**APPLICATION NO:** 20/02453/F

**DESCRIPTION:** A fuel depot including ancillary offices, the installation of plant and hardstanding

**LOCATION:** Hornton Grounds Quarry, Hornton

Viewpoint locations

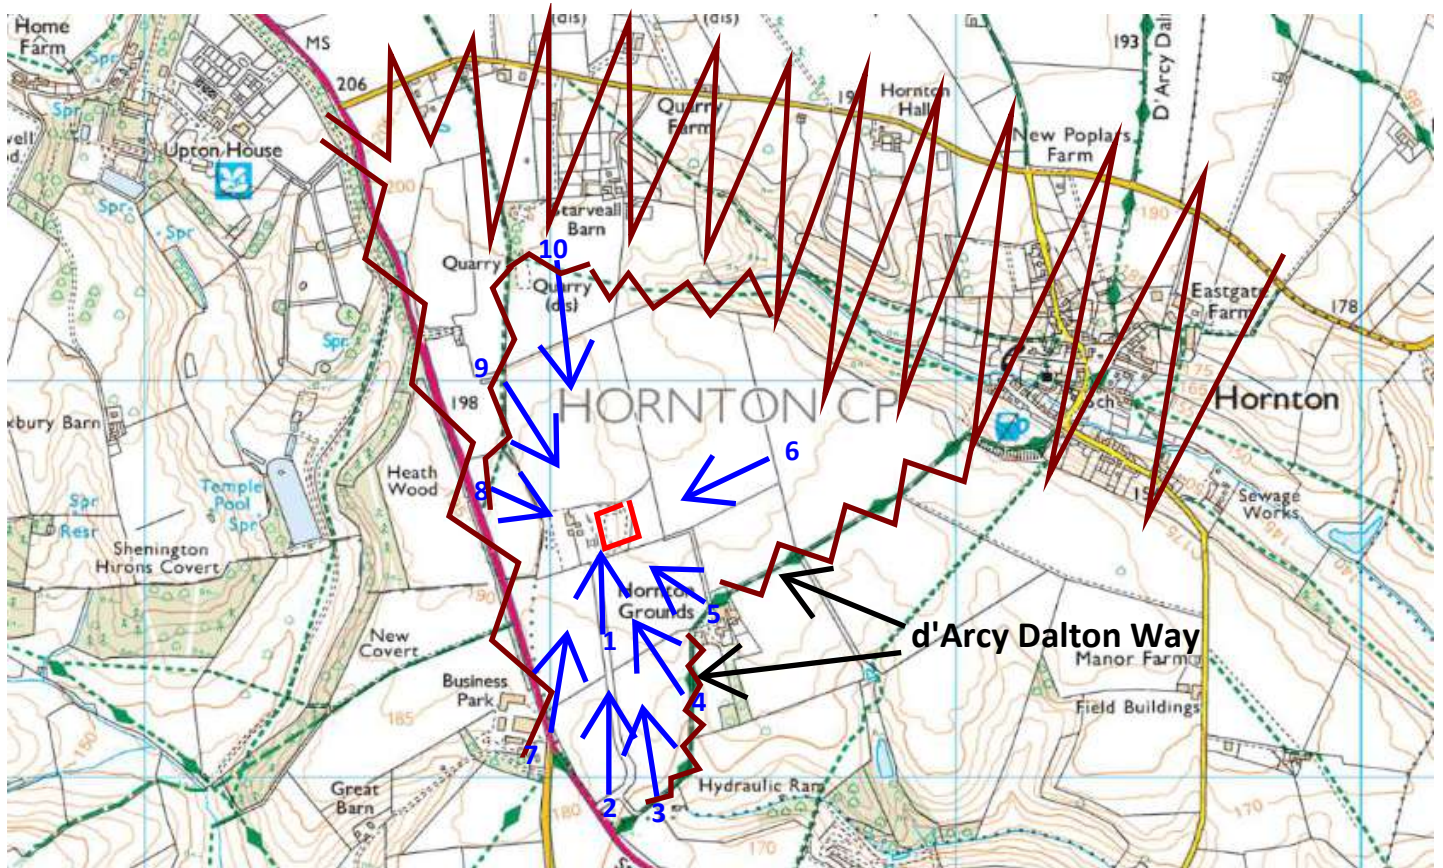
The applicant's Landscape and Visual Impact Assessment (LVIA), including the 'Viewpoint Locations' map on page 10, indicates that the proposed development would not be visible to the west of the A422 or north of the minor road approximately 1km to the north of the site. However, this 'zone of visibility' is very crudely drawn and, as such, does not appear to have a robust basis to it.

Given the close proximity of the proposed development to the Cotswolds National Landscape boundary and the fact that views across the landscape are key features of both LCTs, the Board considers that potential visual effects for receptors within the National Landscape (and on its boundary) should be more thoroughly assessed. This should include an assessment of night-time visual effects, as outlined below in relation to the dark skies of the National Landscape.
